3<sup>rd</sup> December 2025

**Re: ACP Case Number: 323456-25  
Response to Submissions**

Drawing title	FOSTERSTOWN 110kV SUBSTATION PALISADE FENCE PLANNING
Production unit	Transmission and Distribution Delivery

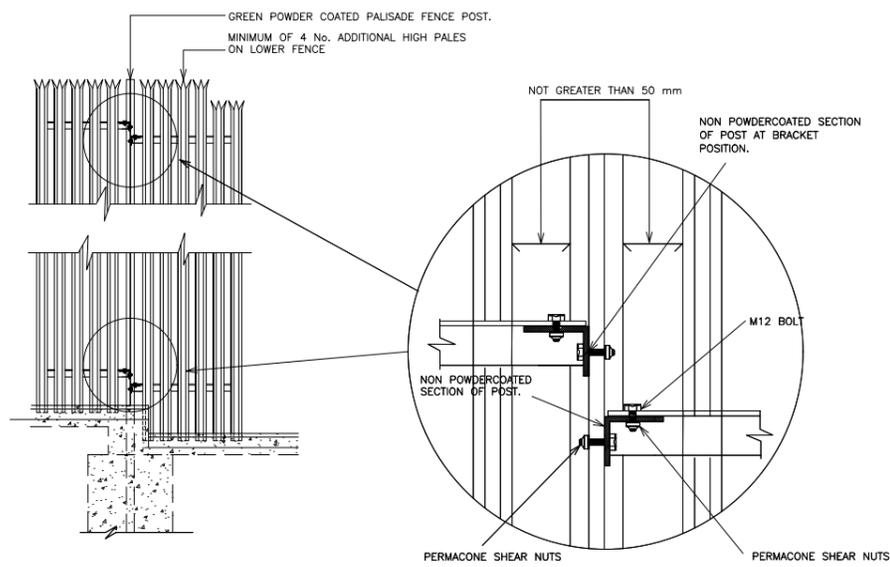
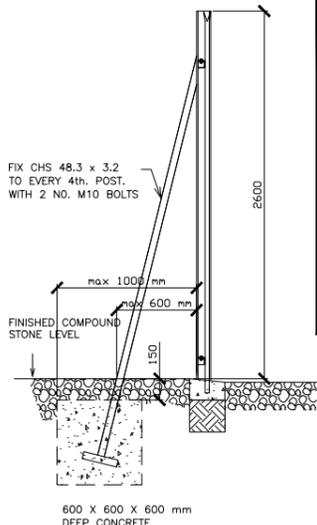
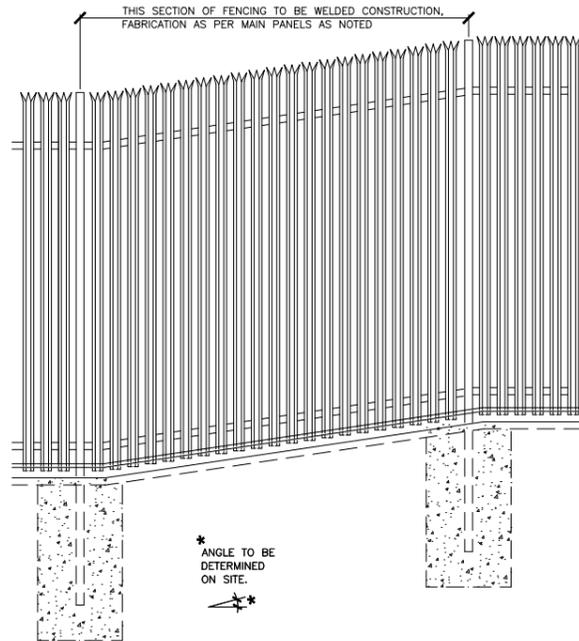
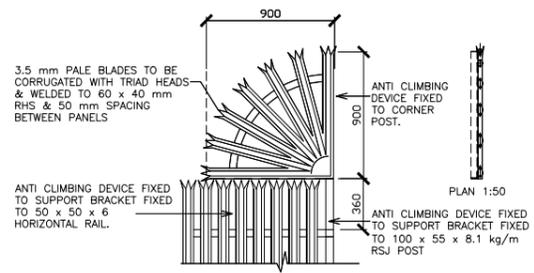
- The Planning Authority suggests an alternative boundary treatment should be sought in the context of the rural setting. ACP to consider the residential amenity of neighbouring properties.

MCC state that should ACP be minded to grant permission for the development, that 6 no. conditions should be considered. **ESB has no objection to the 6 no. conditions proposed in MCC's submission.**
